From: Andrew Thompson
Sent: 24 November 2023 11:09
To: DC Support
Subject: FW: PR8

From: Councillor Ian Middleton [REDACTED]
Sent: Friday, November 24, 2023 1:15 AM
To: Andrew Thompson <Andrew.Thompson@Cherwell-DC.gov.uk>
Subject: RE: PR8

Personal comments from me and Fiona Mawson would be as follows :

Figure 4.2 Illustrative Masterplan (March 2023)

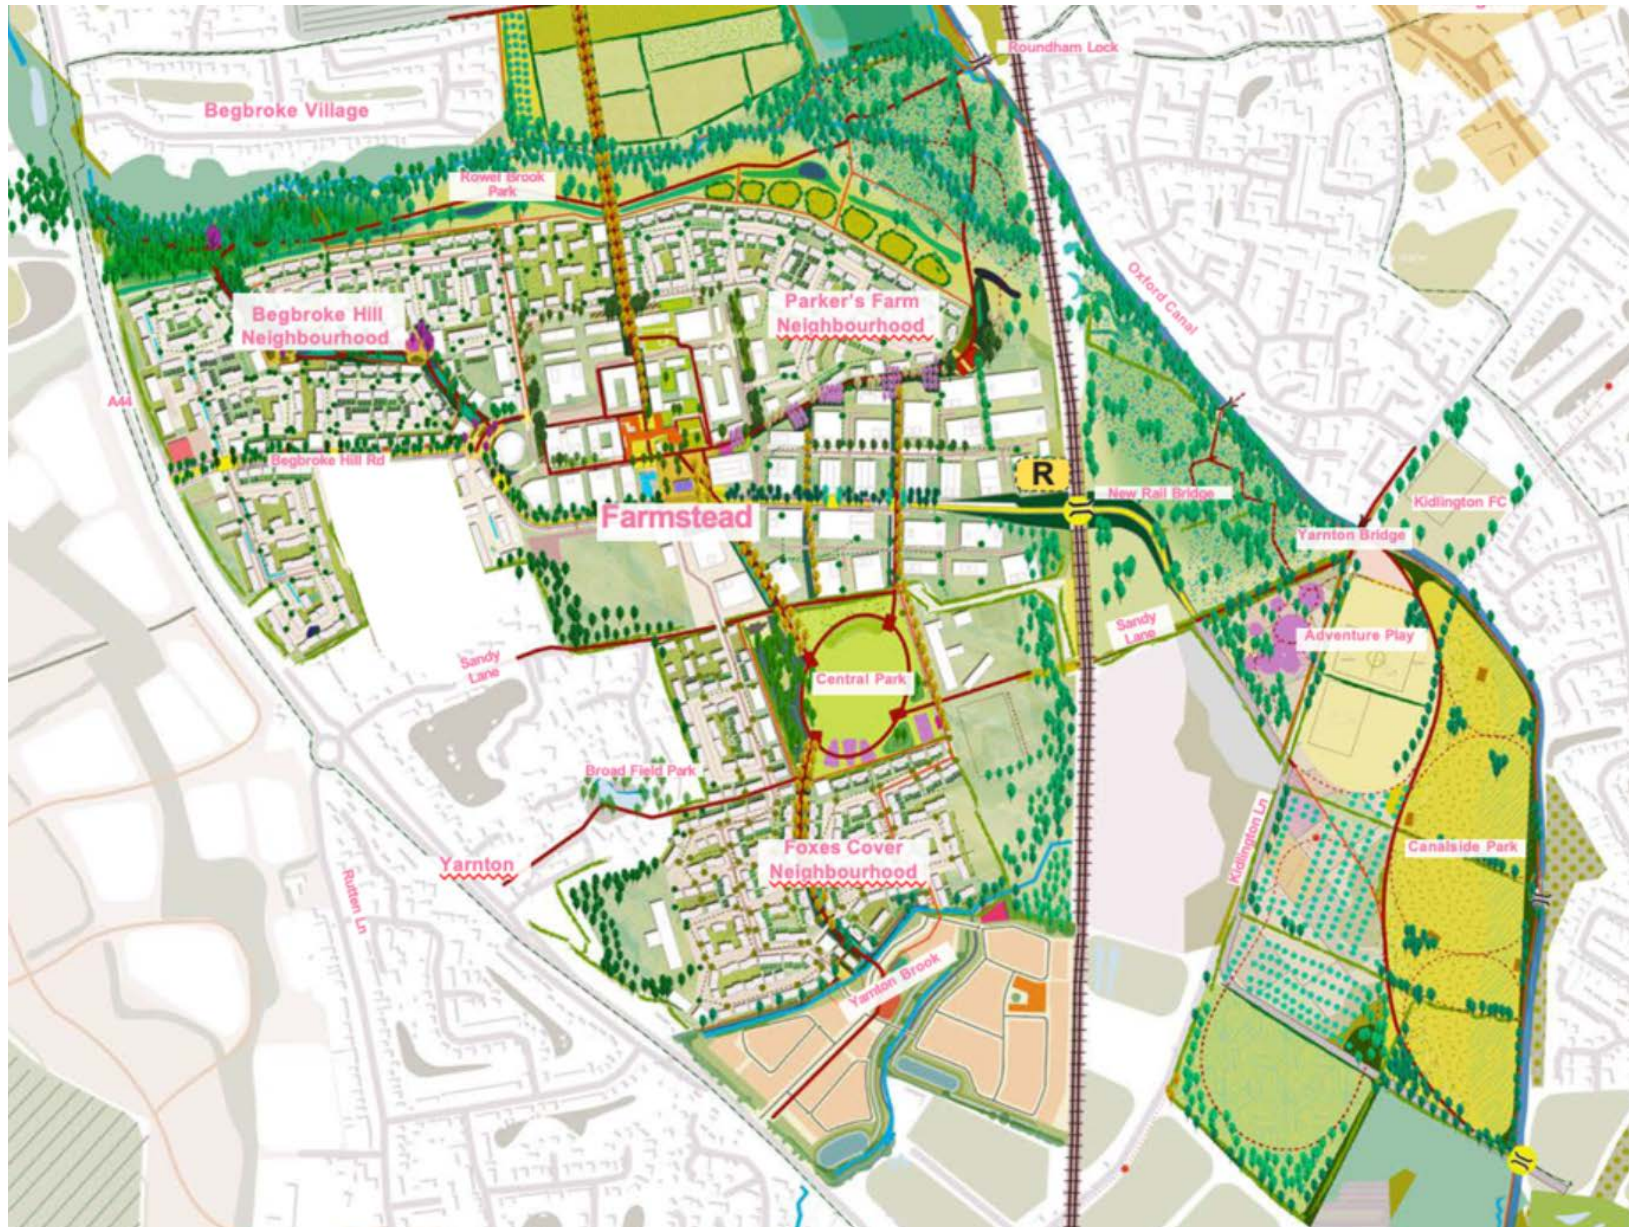
1. I was concerned to see as part of the graphic for the proposed layout of the site that the semi-industrial areas containing science buildings similar to those already on site were predominantly located close to Sandy Lane. This is a largely residential area and may become more so if the other proposals to build an additional residential area on the other side of Sandy Lane goes ahead. In that context it seems incongruous to me that residents will be faced with large and blank monolithic structures virtually on their door steps. This would also seem to be counter-productive to the aims of the overall development as it would devalue the prime real estate areas along Sandy Lane that could become residential communities with a mix of market and affordable housing. Essentially this is already a residential area, so should not be encroach upon by what amounts to an industrial estate.

2. I'd also advocate that the former landfill site should be maintained as planned as a park area and kept as open aspect and rural as possible. This is not only to try to maintain the green and open aspect of the area as it is at the moment but also because there are serious concerns about what is contained within the previously unregulated dumping site beneath. I have detailed files on the types of refuse that was disposed of in the site during its operation and have been advised that as long as the top layer of the site remains undisturbed there is no hazard to the local population. Any attempt to remediate this site for development would be extremely unwise and I trust OUD have taken that on board. The current proposals for this to be parkland would seem the most appropriate use as this would also the area to remain at least partly wilded ensuring that the contents beneath are not released.

3. I would add a plea that any proposed crossing of the railway on the main site be accessed via the new development keeping the main traffic away from Sandy Lane itself. This lane was once a quite country thoroughfare and in the current local plan is earmarked to be an active travel site. Moreover it will serve as an active travel access point to the parkland on the current landfill site. It's unclear from the masterplan graphic if Sandy Lane is intended to be used for vehicular traffic, but I would suggest that in the context of the proposal for the central park area and adjacent green spaces it would be best kept free of motor vehicles for the enjoyment of residents, employees and students and only used for access to the residential areas. This is even more important given that there are proposals for a primary/junior school on Sandy Lane. This would also be an important consideration in terms of the planning context with regard to the industrial type/science blocks being sited near to Sandy Lane.
